DEPARTMENT OF THE ARMY
WILMINGTON DISTRICT, CORPS OF ENGINEERS
151 PATTON AVENUE
ROOM 208
ASHEVILLE, NORTH CAROLINA 28801-5006

Action ID No. 200530150, US 64 relocation from US 19/74/129 in Murphy to east of NC 141.
Cherokee County, North Carolina, TIP No. R-0977A

Subject: Correction to 401 Water Quality Certification for R-0977A, DWQ Project No. 20041594V.4
Water Quality Certification No. 3487

PROJECT REFERENCE NO.	SHEET NO.
	R-977A	6
	HIGHWAY DESIGN ENGINEER	HYDRAULICS ENGINEER
CONST. REV.		
R/W REV.

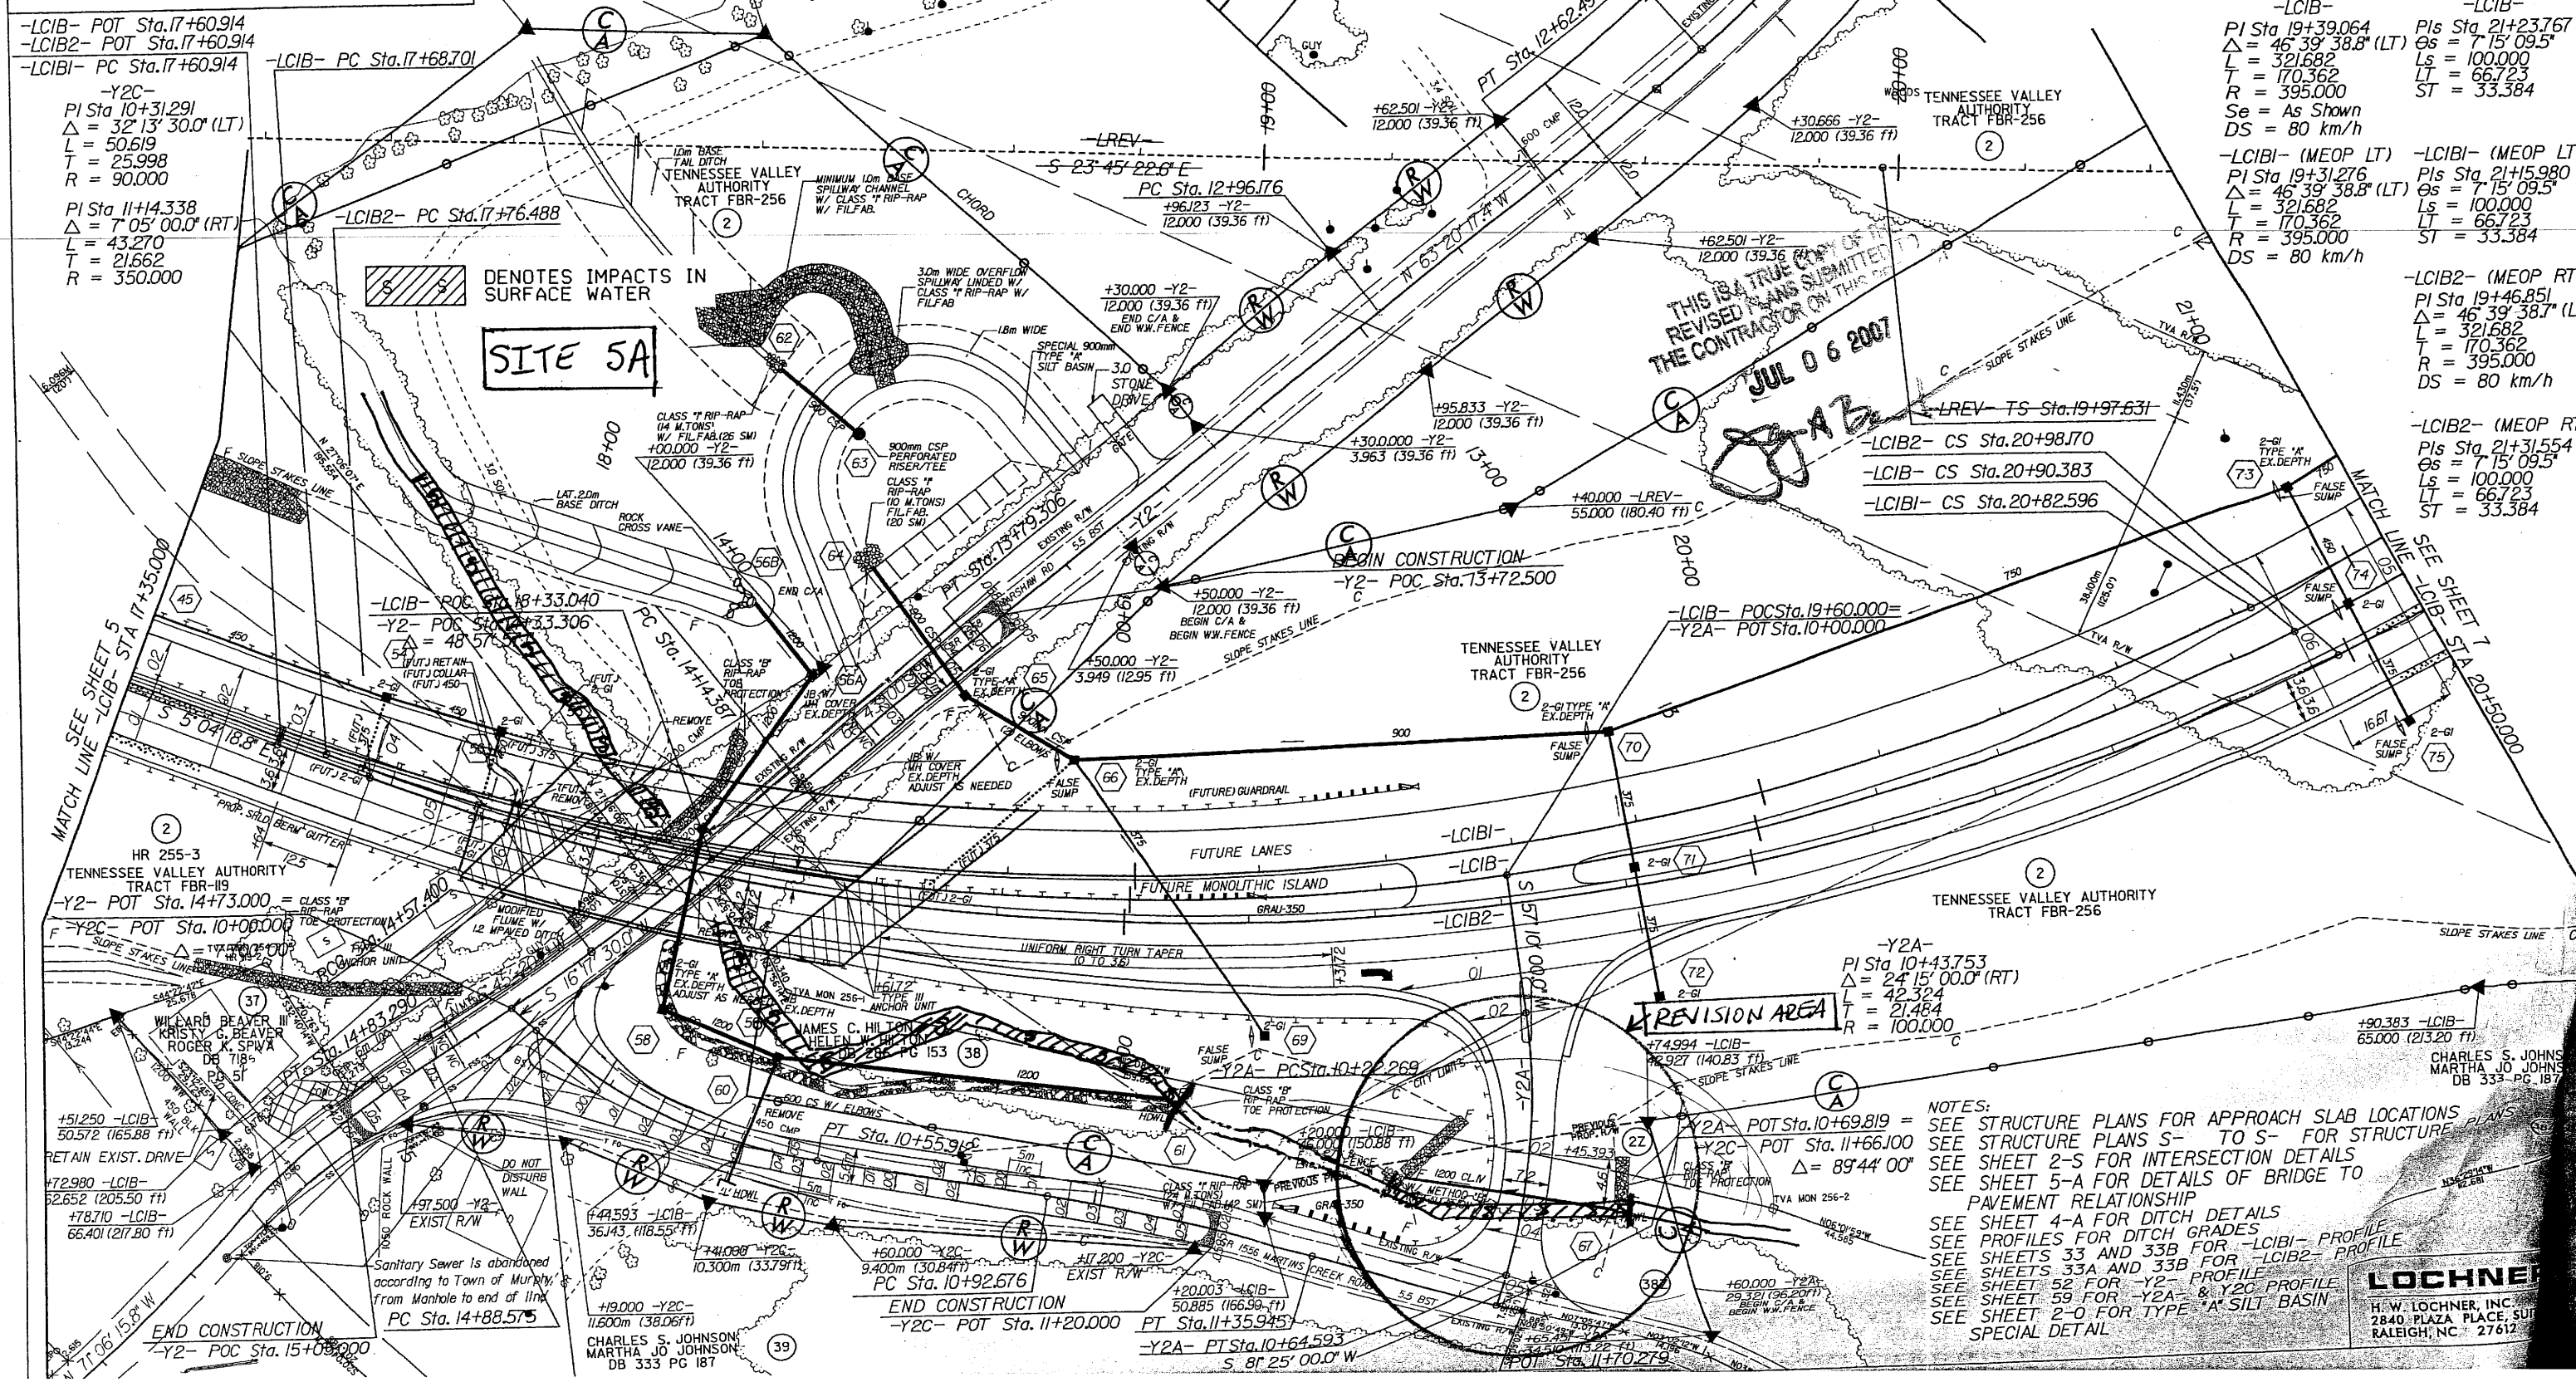
- Site 5A, New access from Martins Creek Road. The new Y-line will require the placement of 131 linear feet of RCP in an unnamed tributary to the Hiwassee River.

PROJECT REFERENCE NO.	SHEET NO.
	R-977A	12
	HIGHWAY DESIGN ENGINEER	HYDRAULICS ENGINEER
	STEVEN C. PROWSE	BOB HATCHETT
CONST. REV.		
R/W REV.

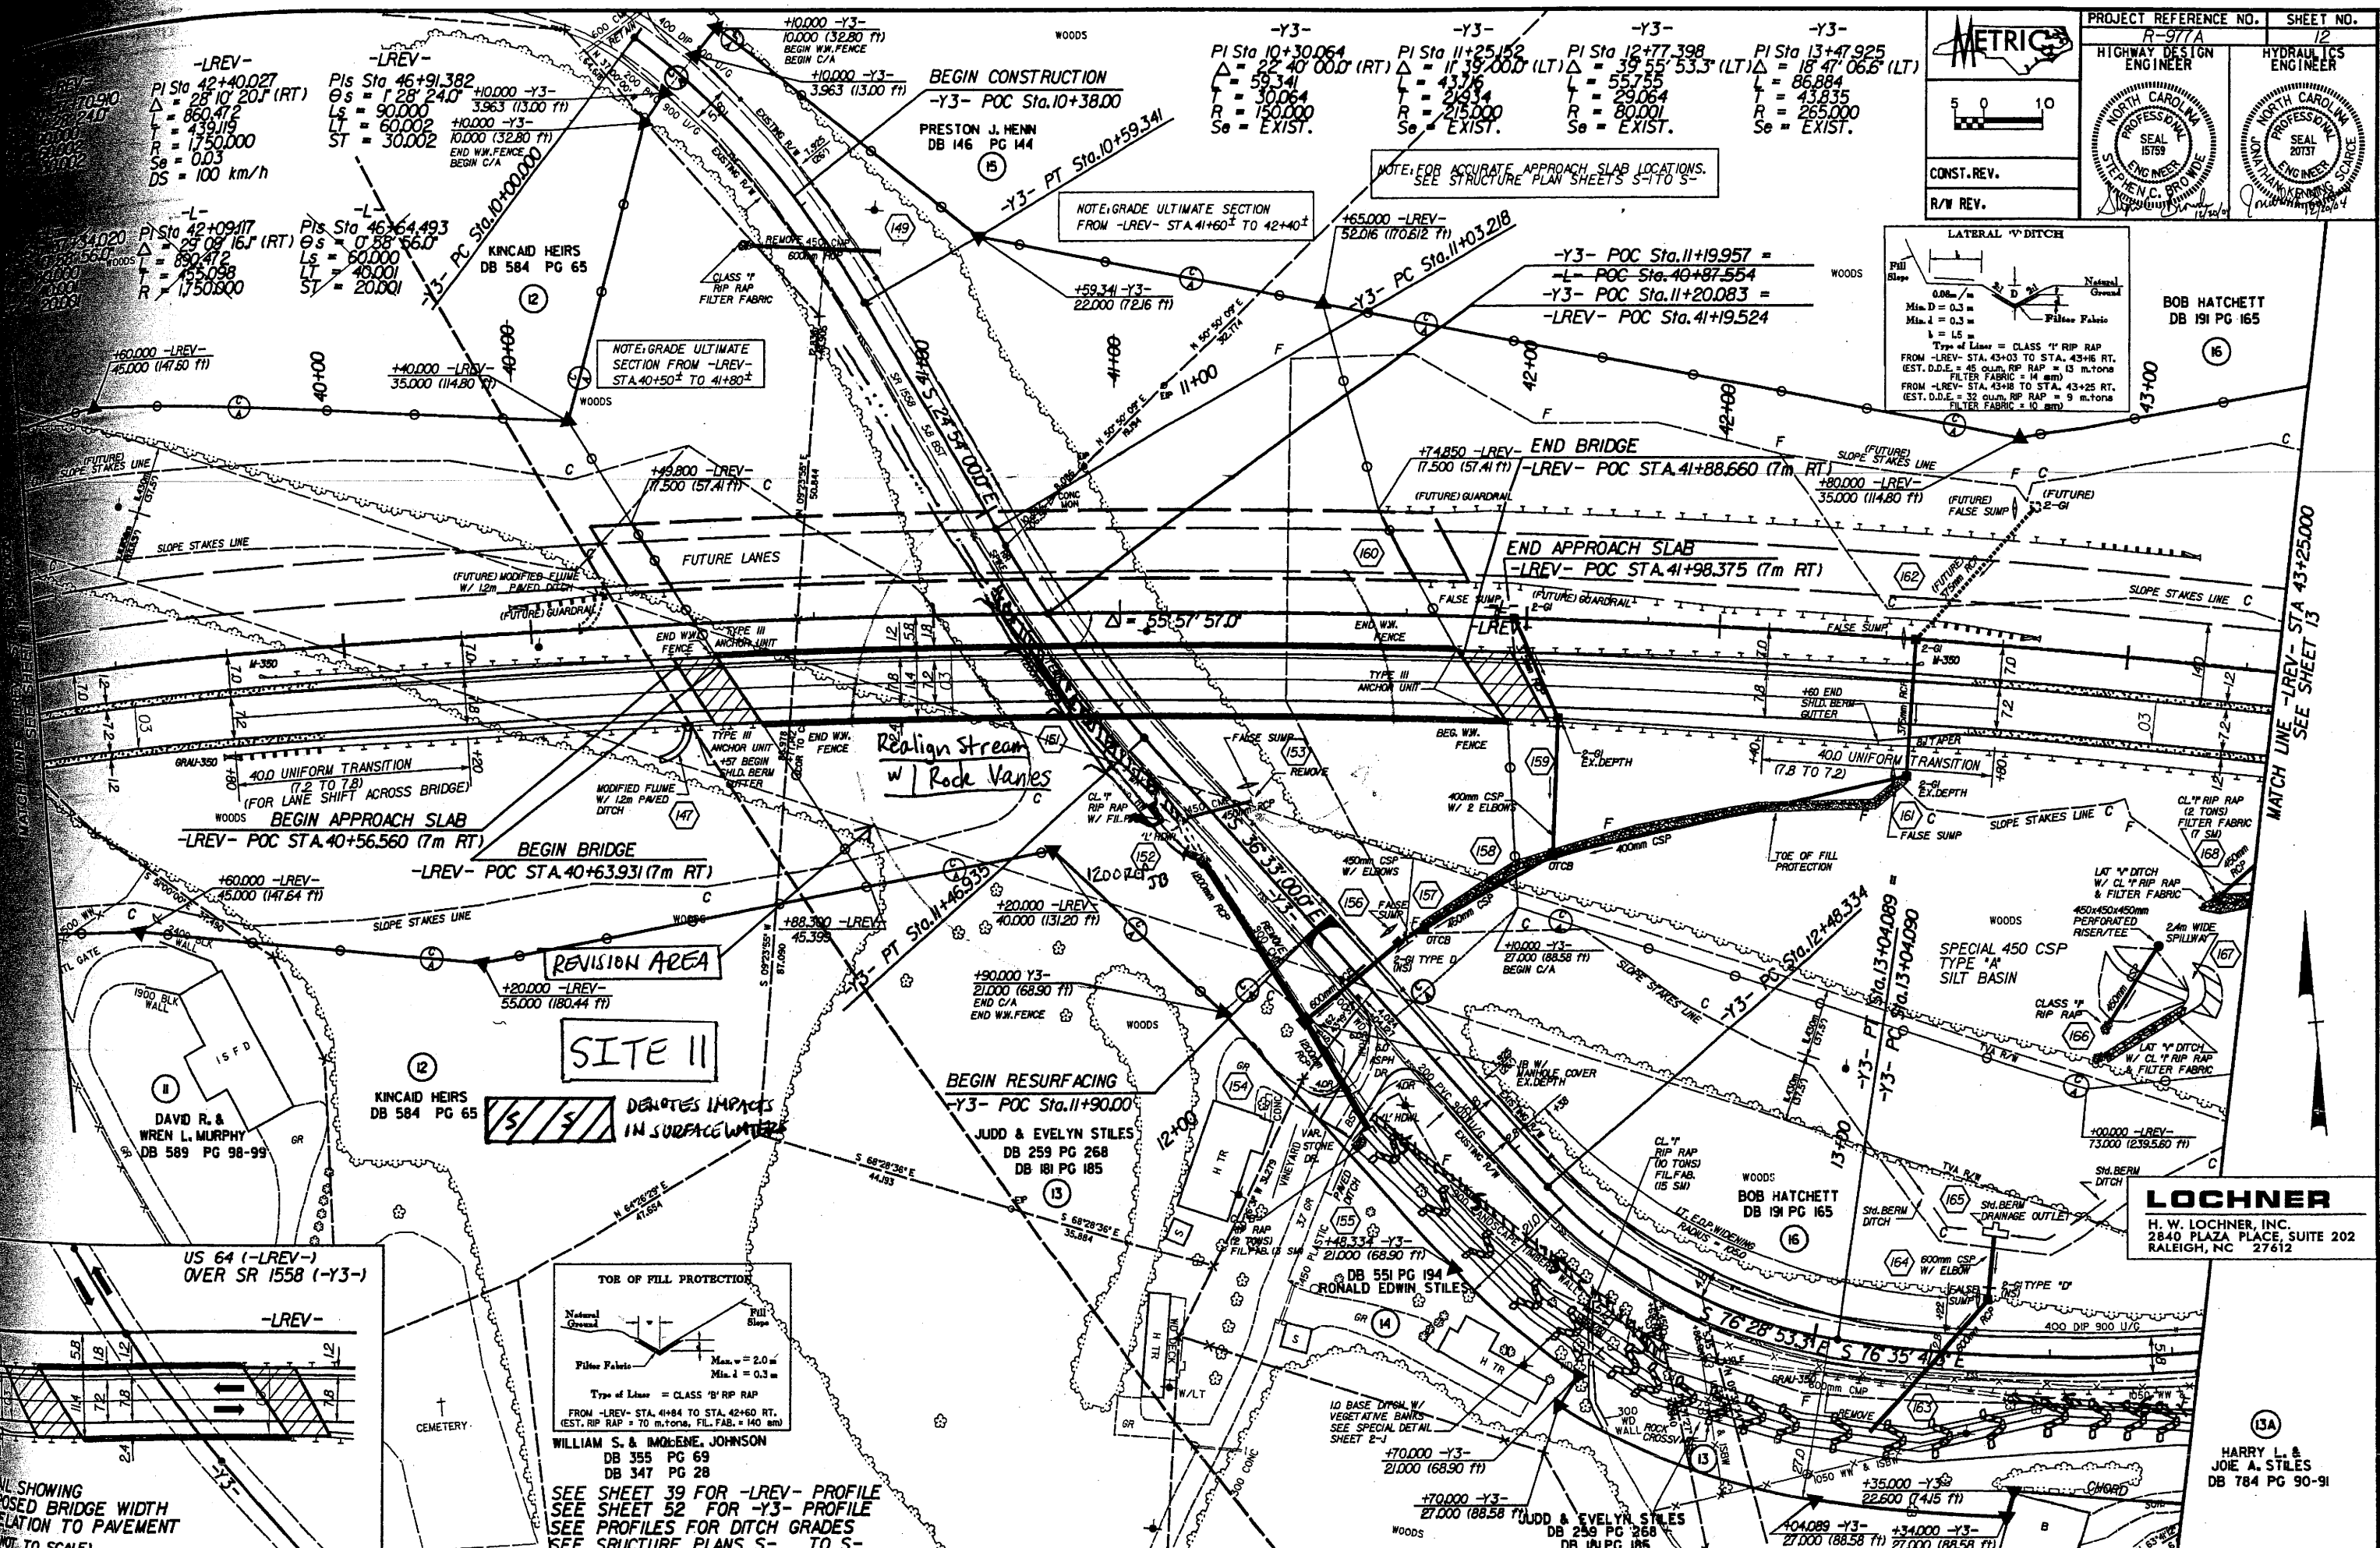
- Site 11, Harshaw Road. The removal of 24 linear feet of RCP and the installation of a 4-foot long junction box. This will also require the relocation of 135-feet of an unnamed tributary to the Hiwassee River using natural channel design techniques to gain additional shoulder width along Harshaw Road.

*Site 11 - 135 linear feet of impact due to stream restoration. A total of 147 linear feet of on-site stream relocation will be conducted using natural channel design.
